## **Wiswell Parish Council's response to planning application 3/2023/1026 23 Pendleton Road.**

**The Parish Council support the application for the refurbishment and extension to the residential property on Pendleton Road (including plans for off-road parking).**

1 PROPOSED SITE PLAN
1 : 200

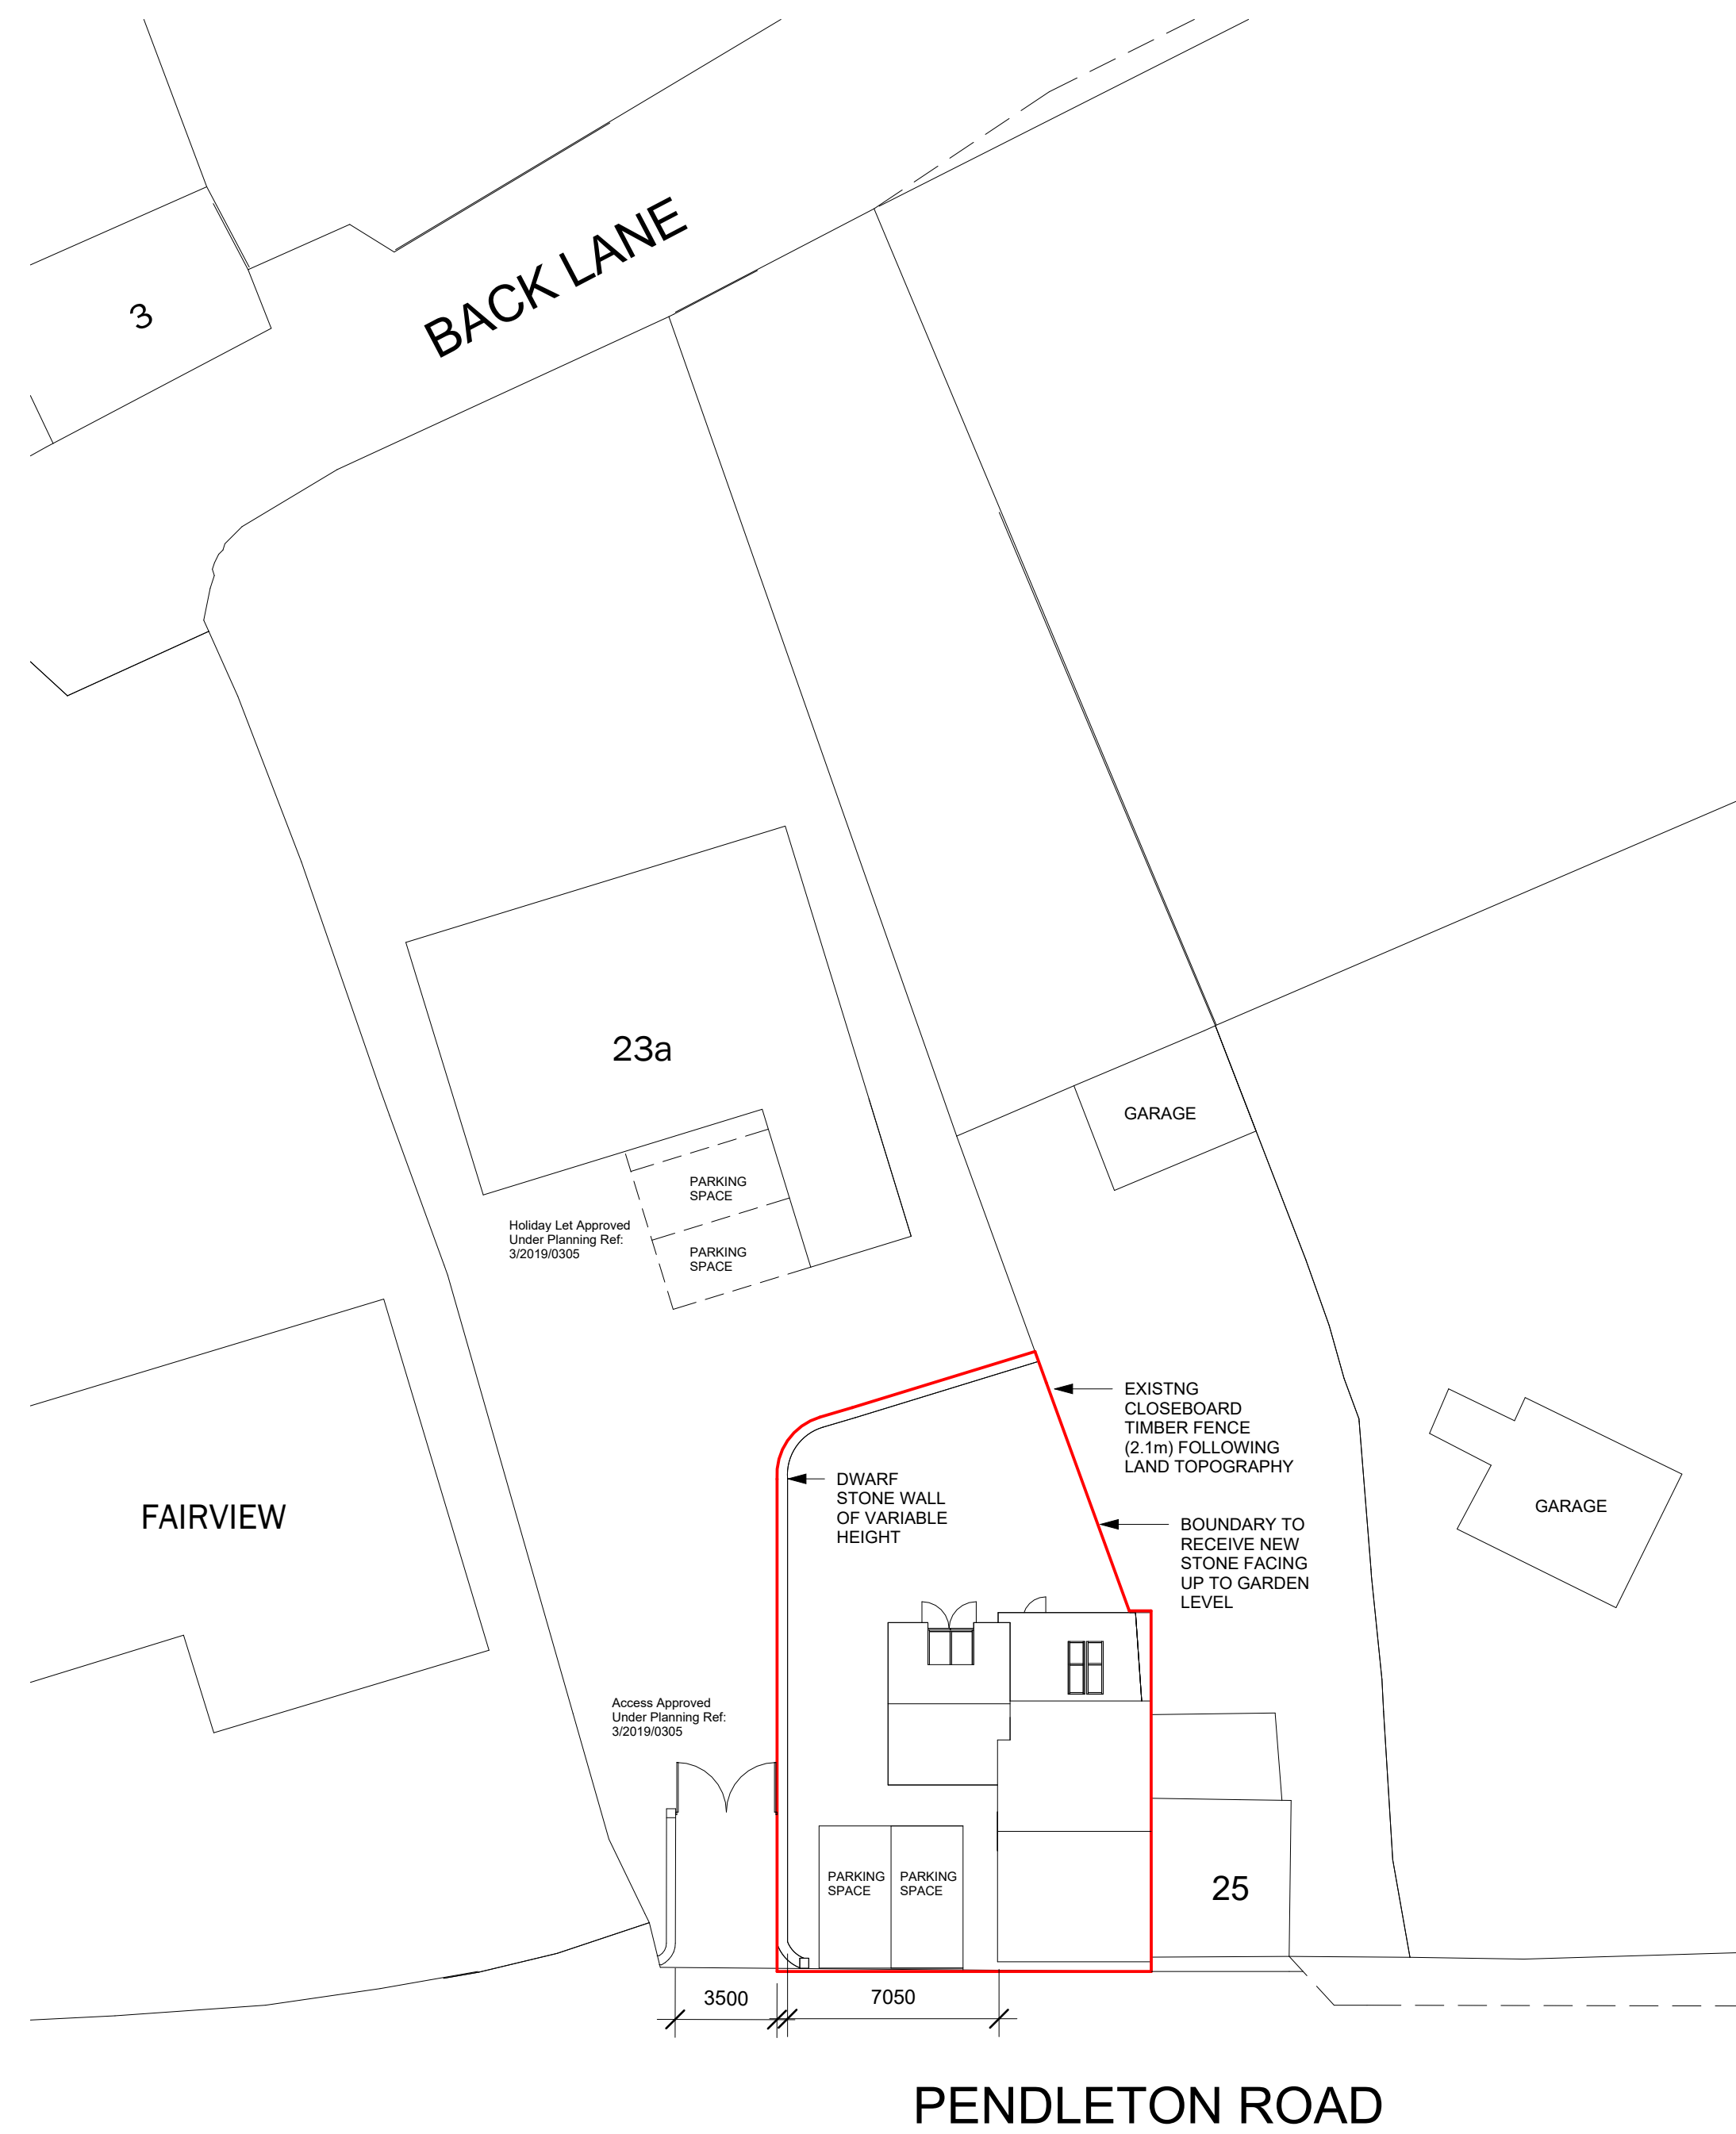
However, the Council note that the external design for access and parking is not in accordance with the details which were approved under 3/2019/0305 (Site Plan dated 9 May 219) when the change of use from the 'dance studio' to a holiday let was approved.

The current proposal includes for two separate entrances each with two separate parking spaces each for the residential property and the holiday let, each side of a new boundary. This leaves the property completely open with no wall replacement possible on Pendleton Road together with the division into two entirely separate curtilages.

1 PROPOSED SITE PLAN
1 : 200

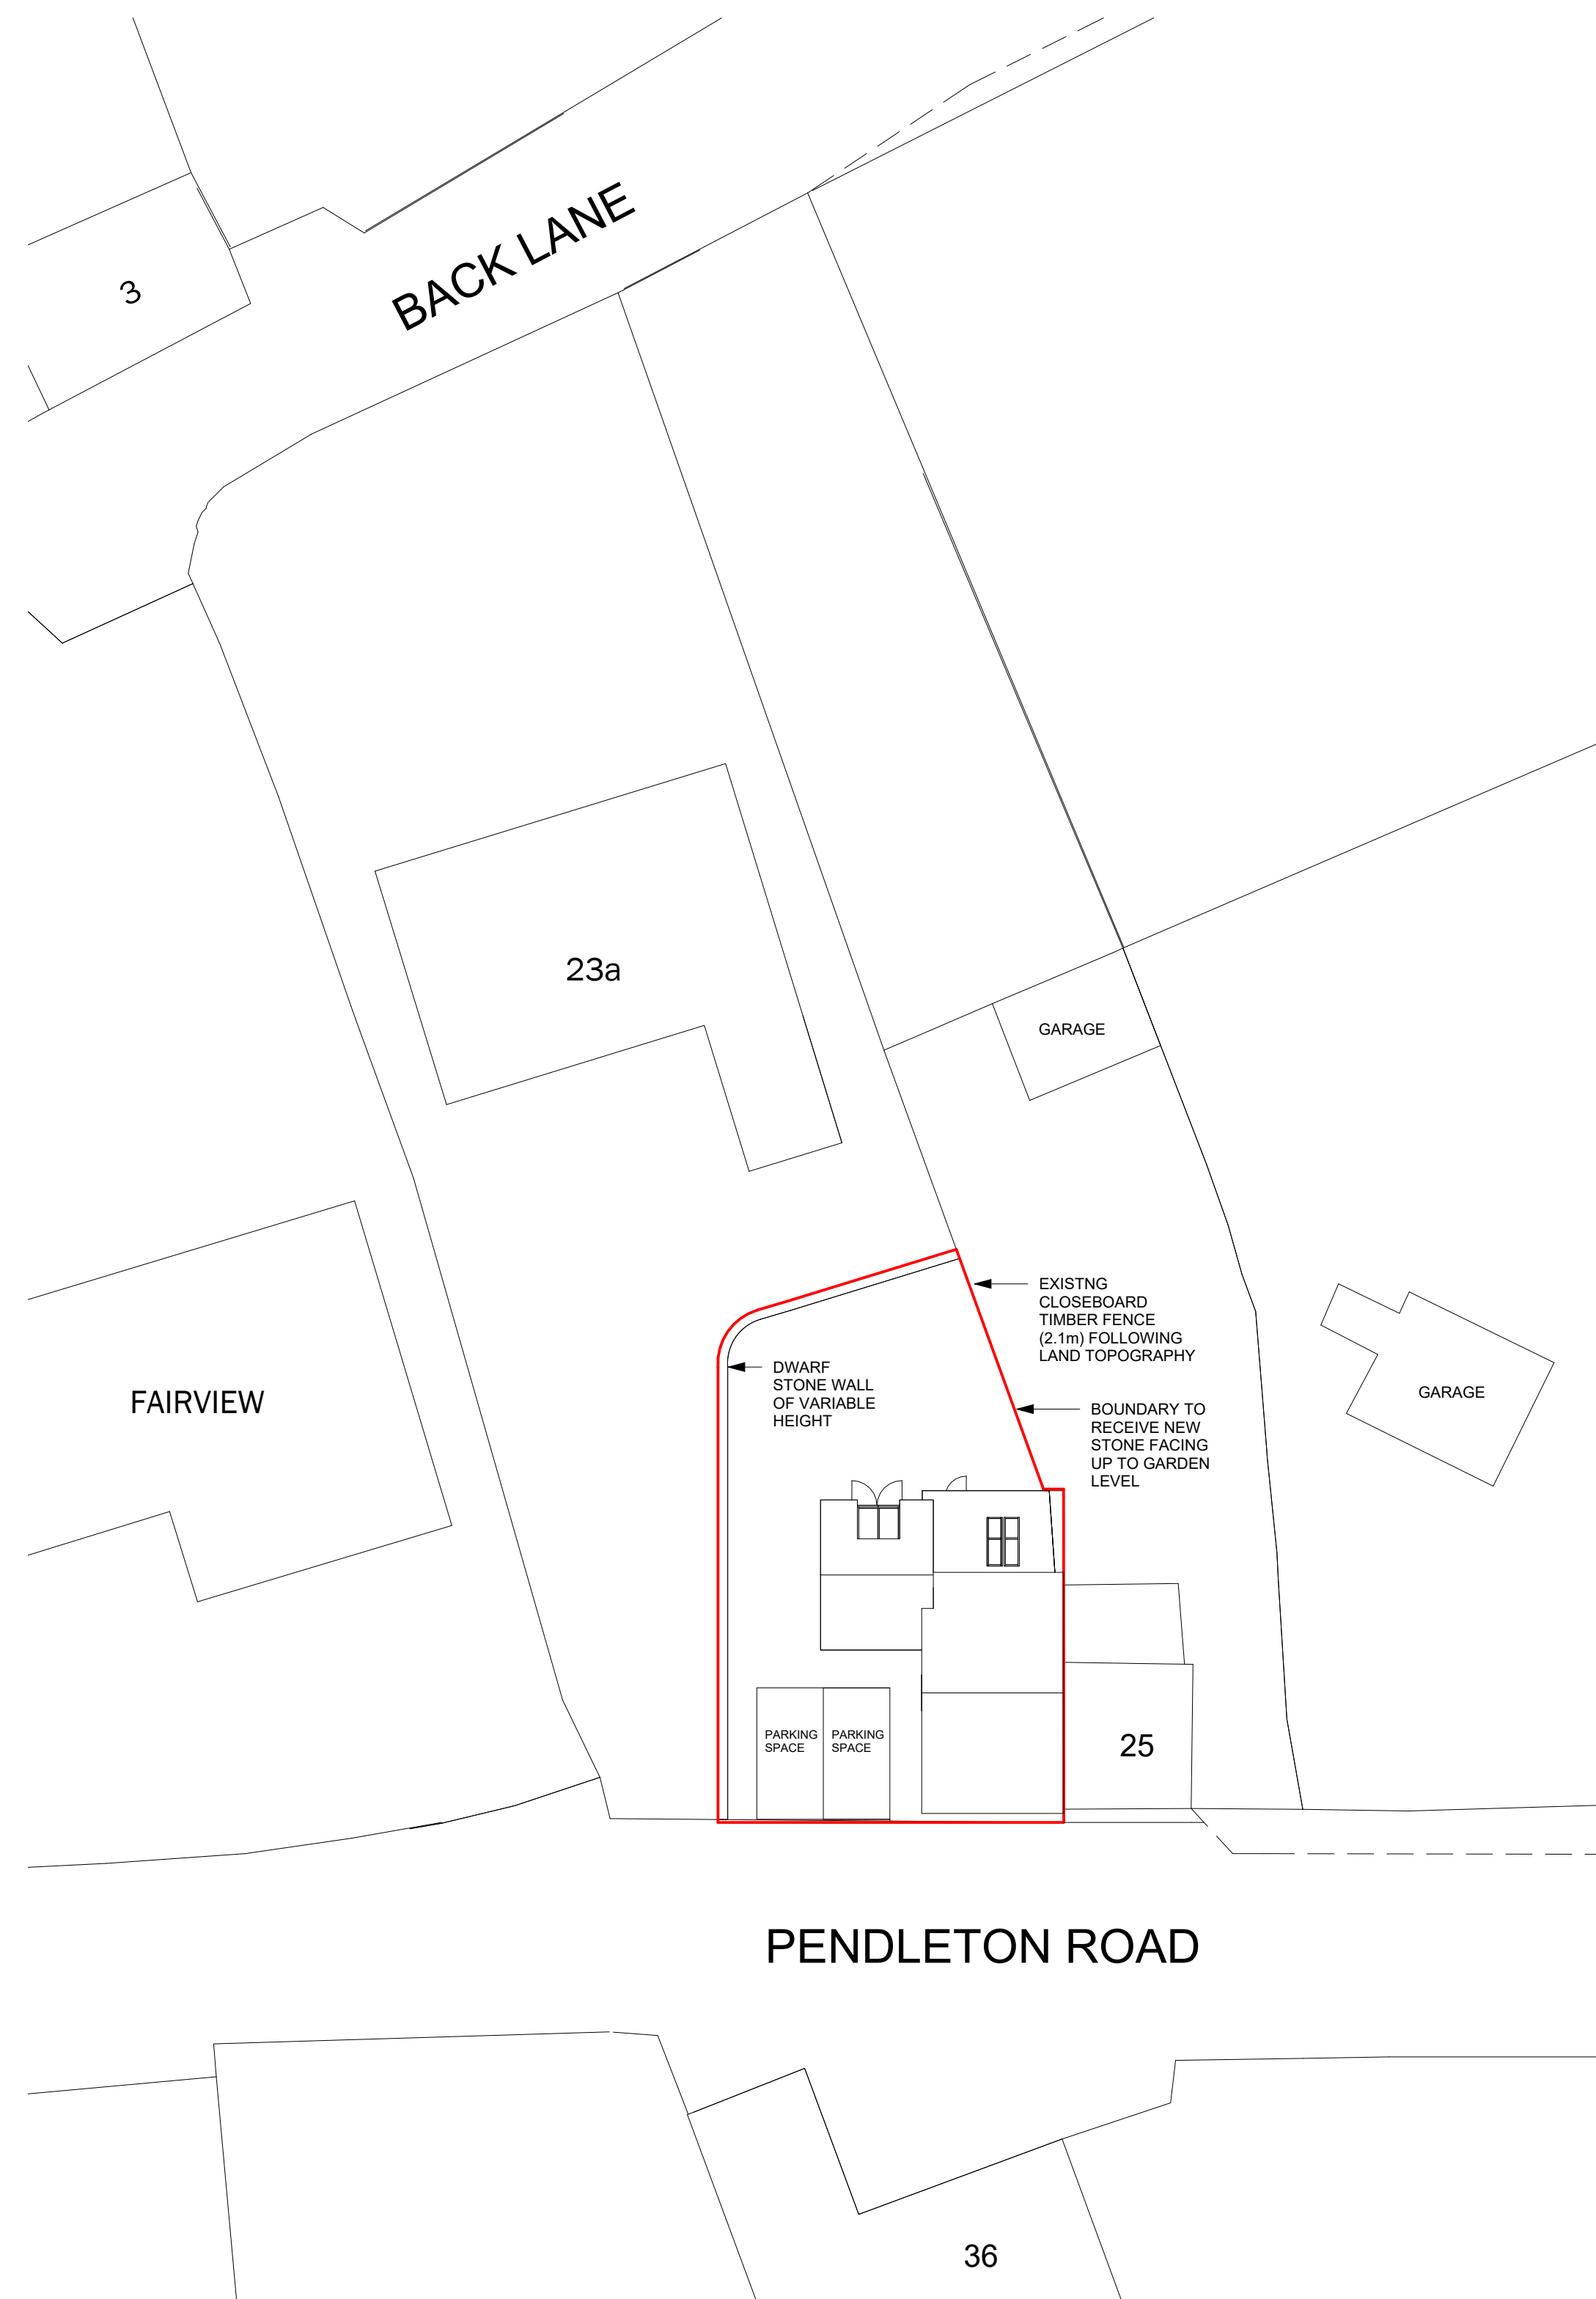
The design under that approval recognised the link under permitted development between the residential property and the new development in that four adjacent parking spaces were served by a single, new entrance off Pendleton Road. Most of the original, heritage stone wall along Pendleton Road would have been restored.

This severs any link between the holiday let and the residential property and the original concept of approval under permitted development rights will be lost for ever, also making a future change to residential status easier to achieve, formally or informally. We also understand that a certificate of lawfulness has never been requested for the original dance studio, so the planning status remains in doubt.
